30 October 2023

Department of Planning and Environment

## **OBJECTION: CABBAGE TREE ROAD SAND QUARRY – MODIFICATION 3** **State Significant Development Application SSD-6125-Mod 3**

Figure 1
Proposed Amendment to Cabbage Tree Road Sand Quarry and Biodiversity Stewardship Site Boundary

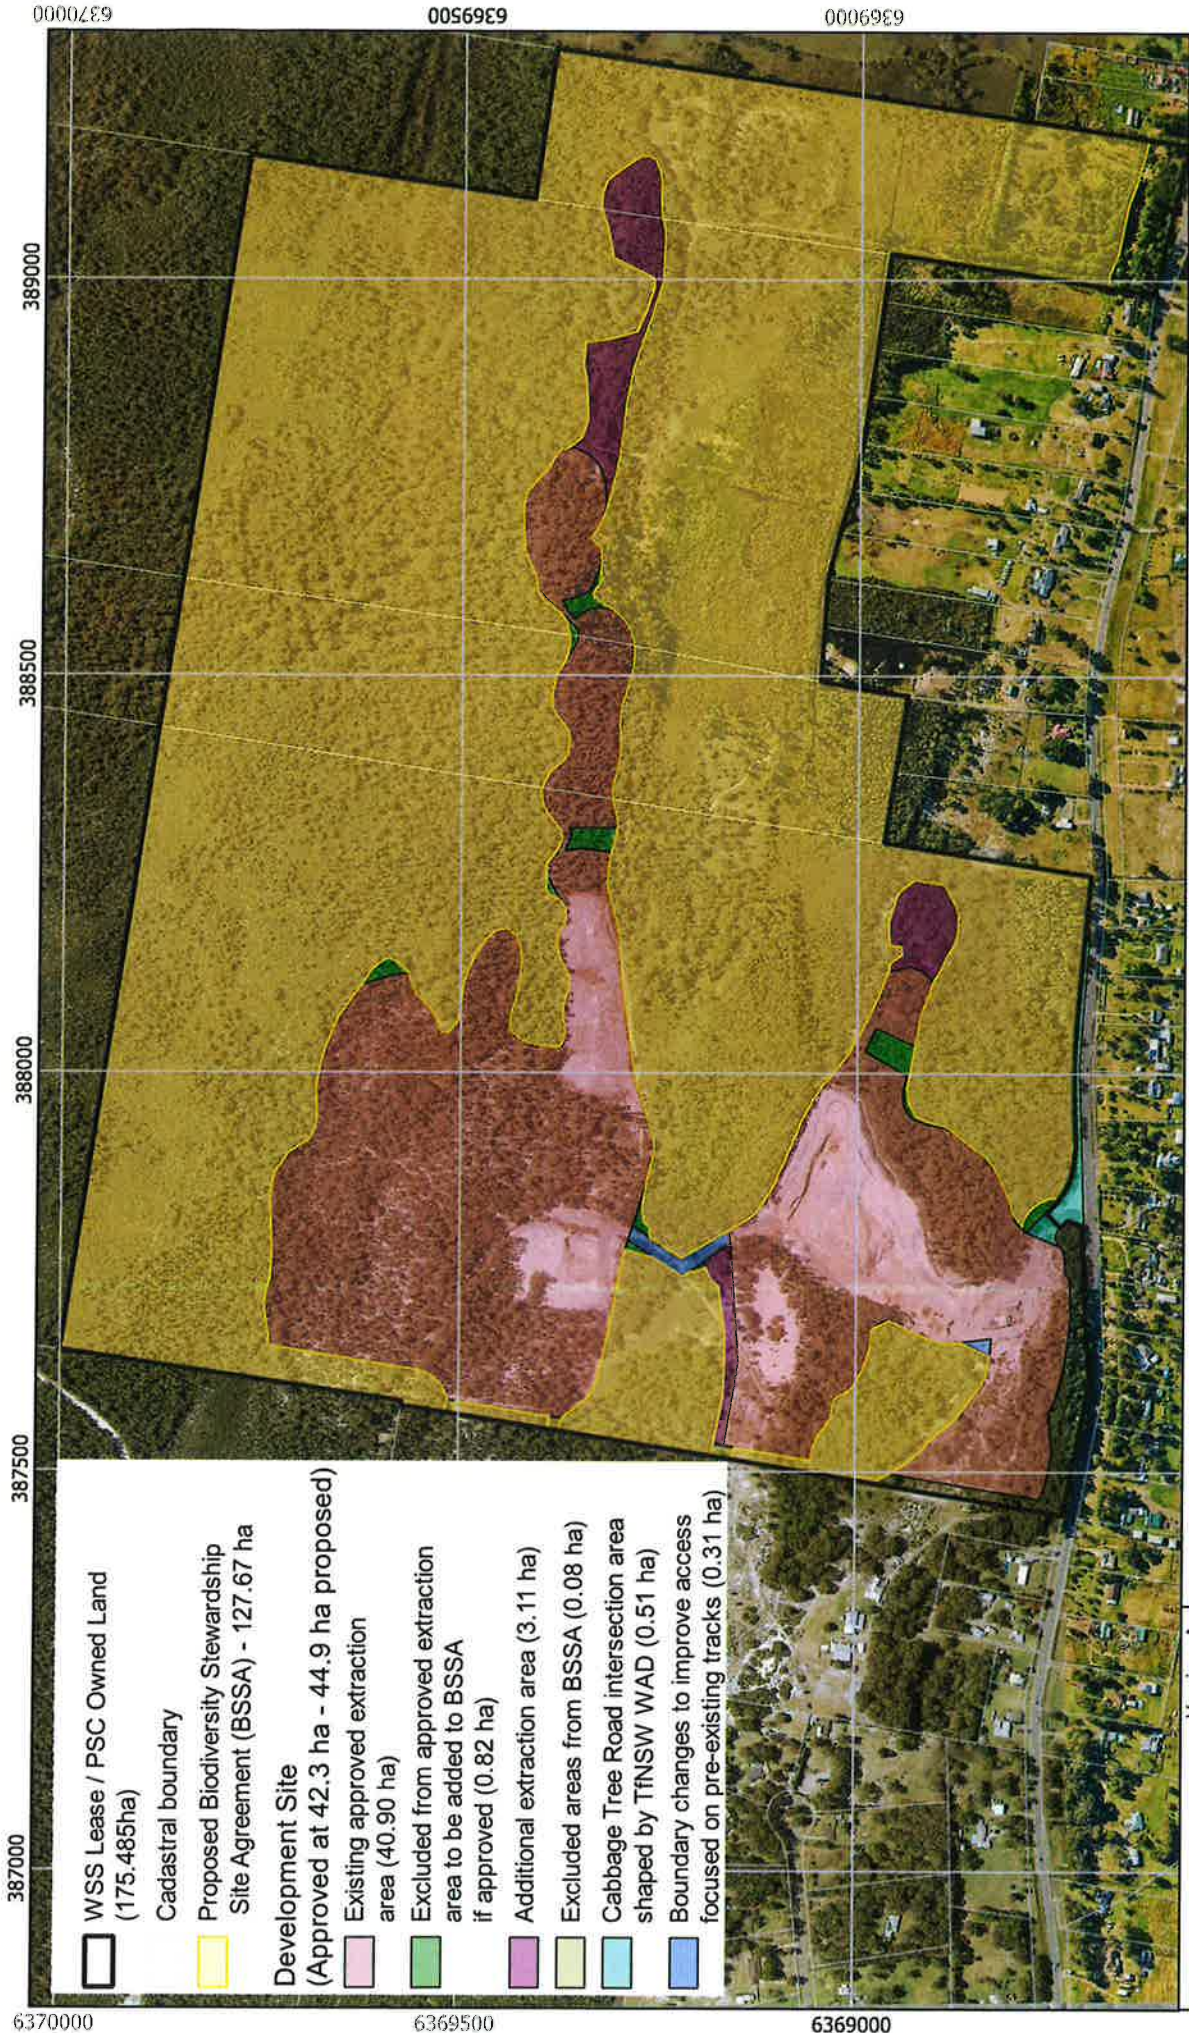
The Proponent now seeks to change the quarry boundaries by expanding into two sections previously removed from the quarry footprint (Mod3 sections 7C-E and 10A-E) and encroaching into a reserved wildlife corridor (Mod3 sections 8A-E and H1-2). As mitigation for biodiversity impact, the Proponent proposes to reserve several small fragments across the original quarry footprint and retire additional biodiversity credits offsite.

The mitigation now being proposed is insufficient: it would not be consistent with key objects of the *Environment Planning and Assessment Act 1979* for an agreed on-site Biodiversity Stewardship site to be largely split in two and further fragmented, and for one of the key connections to other intact forest, the originally reserved wildlife corridor, to be narrowed to a pinch point.<sup>14</sup>

<sup>14</sup> Refer map above. The area proposed to be cleared in the original reserved wildlife corridor (H1, H2 and 8A-E) is 0.44 ha larger than the area to be reserved (X1 and X2). Modification Report No. 3, sec. 4.2, Table 4-2, p 14
